Location of Construction: <b>251 Danforth St</b>		Owner: <b>Chalen Baldic</b>		Phone:	Permit No: <b>981209</b>
Owner Address:		Lessee/Buyer's Name: <b>PWNPC 255 Danforth St Pld, ME 04102</b>		Phone:	Business Name:
Contractor Name: <b>TBA/Scott Simonds Architects</b>		Address: <b>15 Franklin Art Pld, ME 04101</b>		Phone:	
Past Use: <b>Commercial</b>	Proposed Use: <b>Day/Care Community Policing Ctr.</b>		<b>COST OF WORK:</b> \$ <b>35,000.00</b>	<b>PERMIT FEE:</b> \$ <b>195.00</b>	<div style="border: 2px solid black; padding: 5px; text-align: center;"> <b>PERMIT ISSUED</b>  <b>OCT 23 1998</b>  <b>CITY OF PORTLAND</b> </div>
			<b>FIRE DEPT.</b> <input type="checkbox"/> Approved <input type="checkbox"/> Denied	<b>INSPECTION:</b> Use Group <b>5/B</b> Type <b>5B</b>	
Proposed Project Description: <b>Interior alterations to existing first floor space</b>			<b>PEDESTRIAN ACTIVITIES DISTRICT (P.A.D.)</b>		Zone: <b>B-1</b> CBL: <b>057-B-024</b>

PROJECT TITLE:  
Danforth St. Daycare and  
Comm. Policing Cntr.

## BUILDING PERMIT REPORT

DATE: 22 OCT. 1998 ADDRESS: 251 Danforth St. CBL. 057-B-024  
REASON FOR PERMIT: Interior alterations To First Floor / Change of USE Daycare  
BUILDING OWNER

Window Schedules

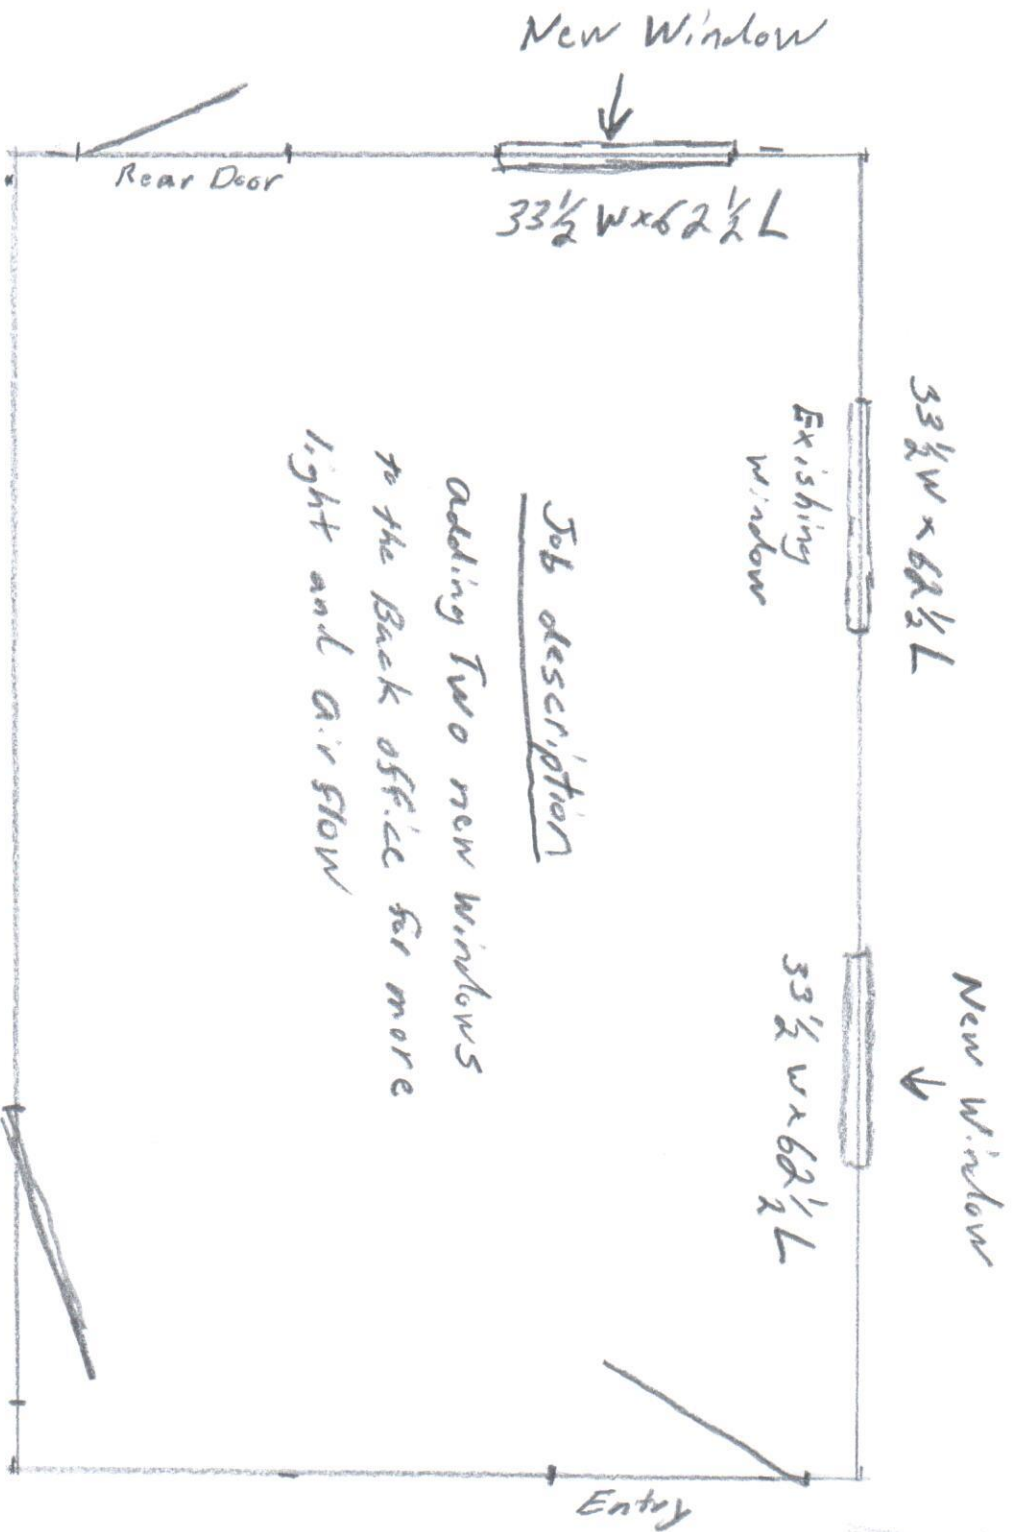
35. Your plans did not show header sizes of windows - Please submit this information for review.
36. If there are over 13 children - a monitored system (Alarm) or ESS or master box must be used.
